Please ask for: Mrs D Johnson
Email: daun.johnson@arun.gov.uk
Telephone: 01903 737762
Our Ref: LU/134/21/PL
Your Ref:
Date: 29th April 2021

Application for Planning Permission

Development: Subdivision of a single listed building into 2 No. separate dwellings & essential roof strengthening work. This site may affect the setting of listed buildings, affects the character & appearance of the East Street Conservation Area & is in CIL Zone 4 (Zero Rated) as other development.

Location: The Farm 39 East Street Littlehampton BN17 6AU

Location Plan
1:1250

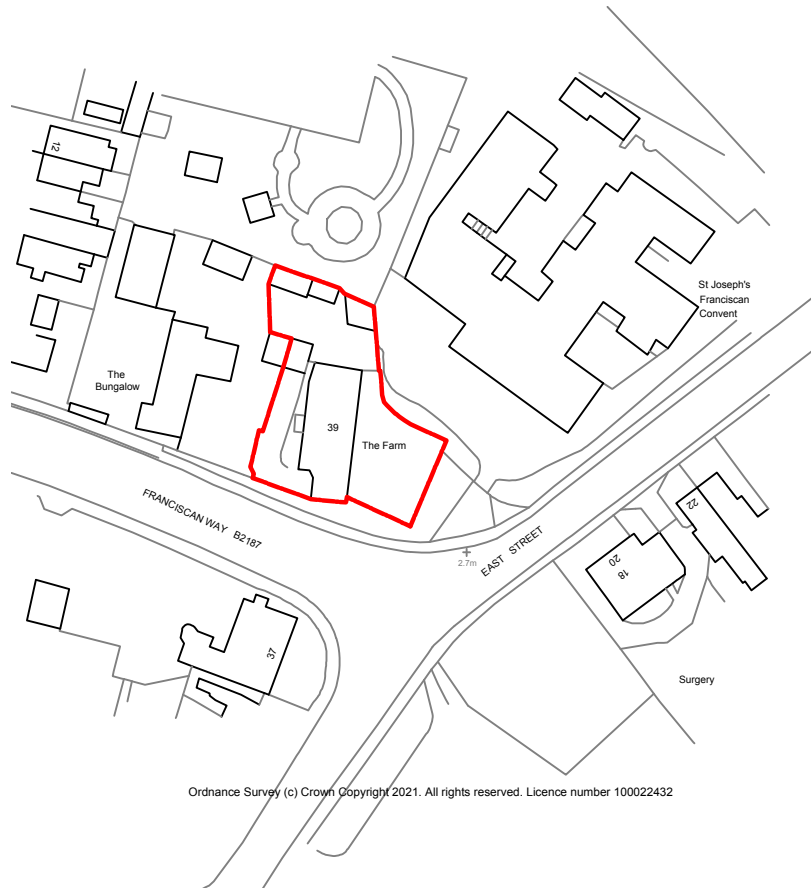
Location Plan

Please provide two named roads.
